CITY OF ALBUQUERQUE

July 27, 2012

RE: **Explora** Science Center, Phase 1 – Grading & Drainage Plan for Building Permit
1701 Mountain Road N.W. P.E. Stamp: 6/18/12 (**J13-D070**)

DRAWING TITLE: DRAINAGE PLAN AND CALCULATIONS

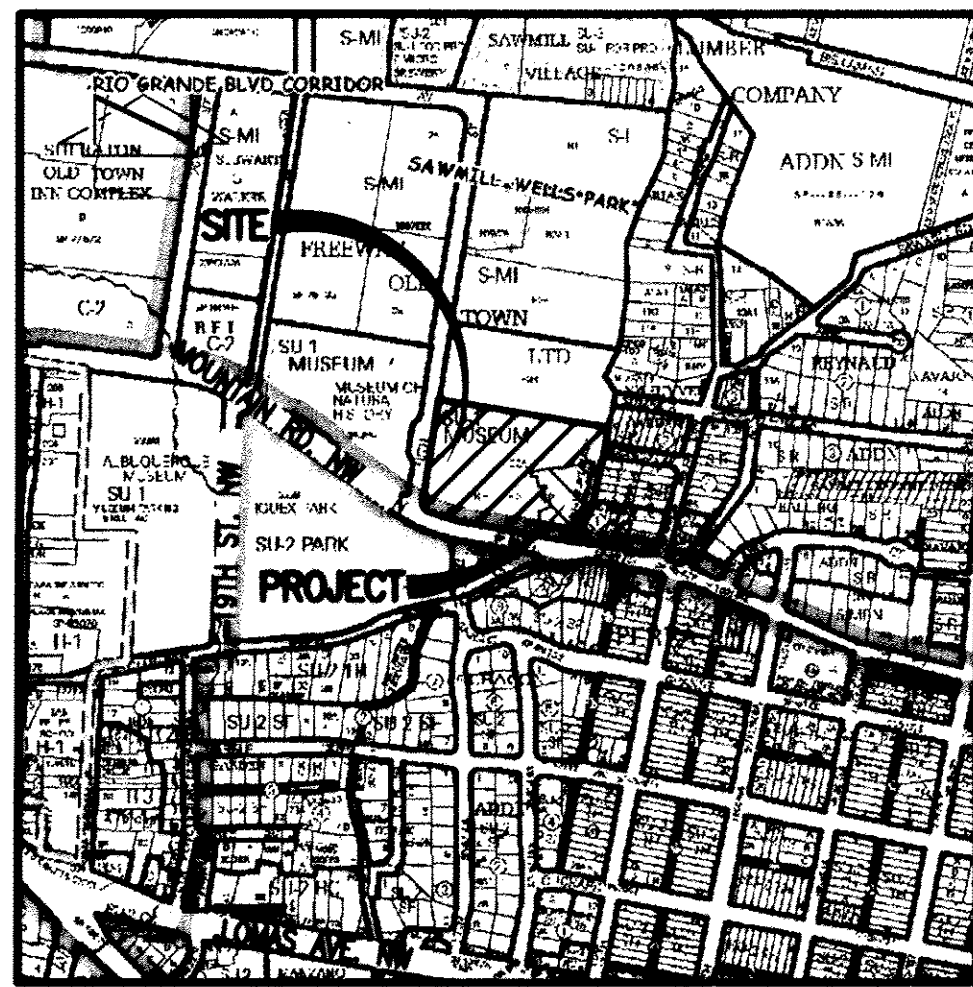
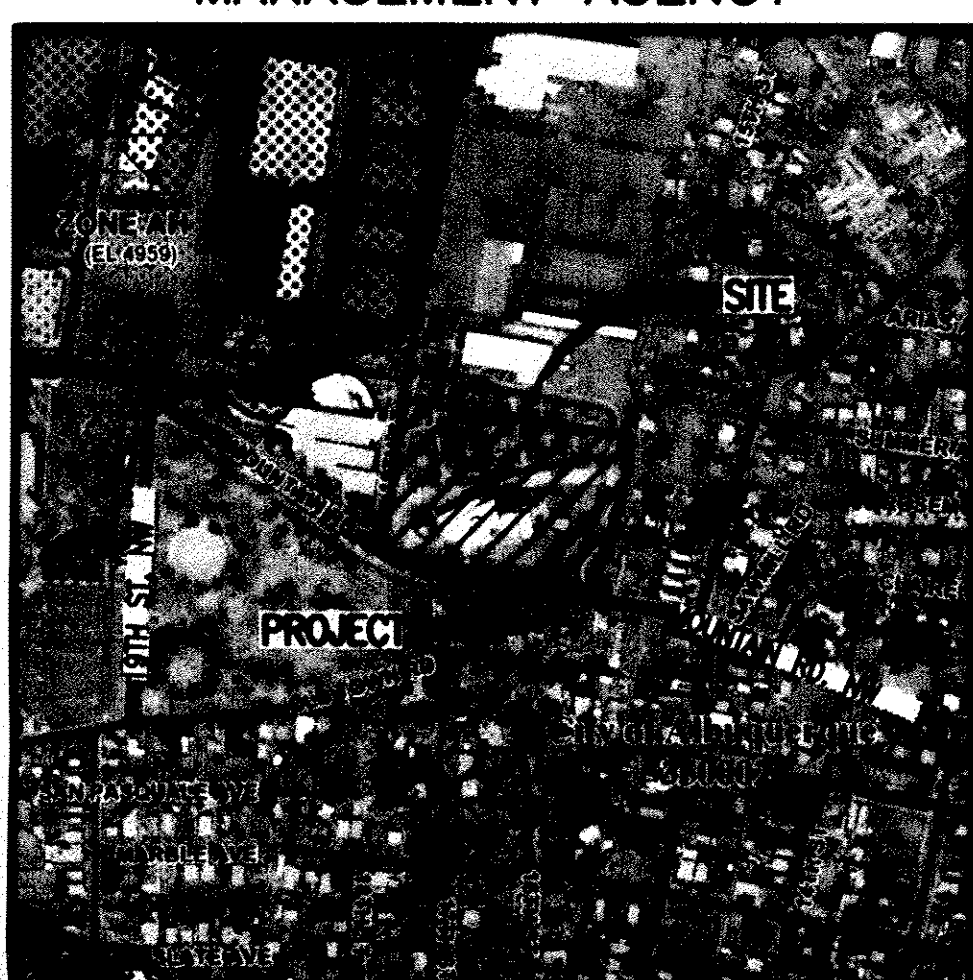
- Hydraulic calculations for this plan included future development of Phases 2 & 3. When you submit your Certification of completed construction, please include a revised basin map reflecting the new Phase 2 & 3 boundaries.
- Verify with the project Architect that leaving the 8" PVC storm drain under the Phase 1 building improvements will not jeopardize either the pipe or the building.
